CITY OF ALBUQUERQUE

April 25, 2019

Re: Maverik Store
Los Volcanes Rd. / Unser Blvd.
Traffic Impact Study Comments
Engineer's Stamp dated 03-11-19 (K10D023D)

## EXHIBIT A

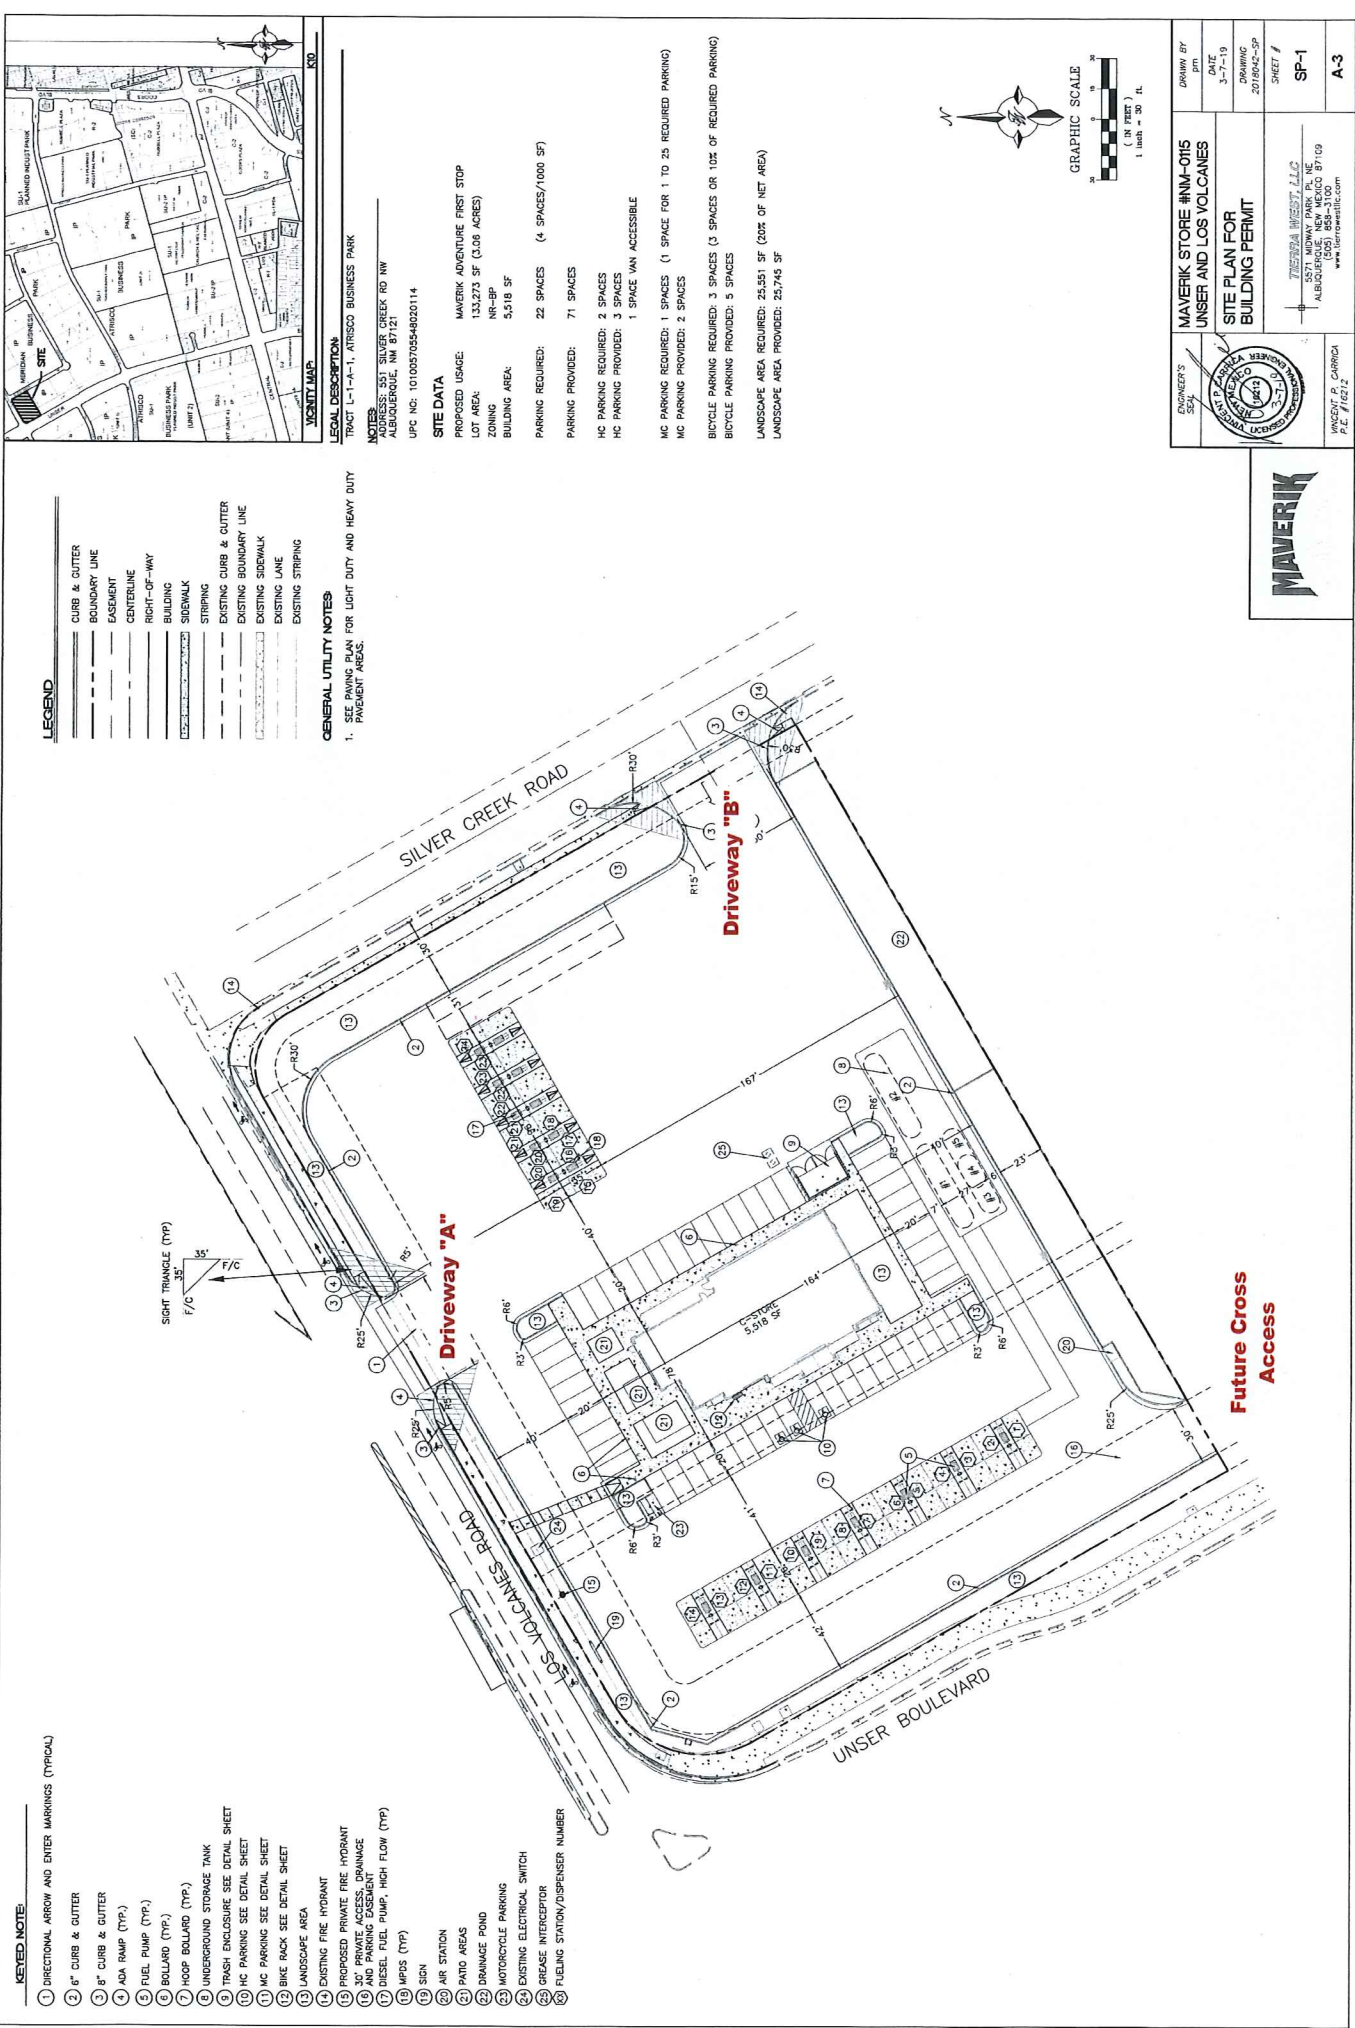
Comment #3 was not completely addressed. We had asked that the distances from Driveway A to Unser and Silver Creek be provided. A drawing was provided, but these specific dimensions were not given. We were able to scale these close enough for our purposes so a resubmittal will not be required.
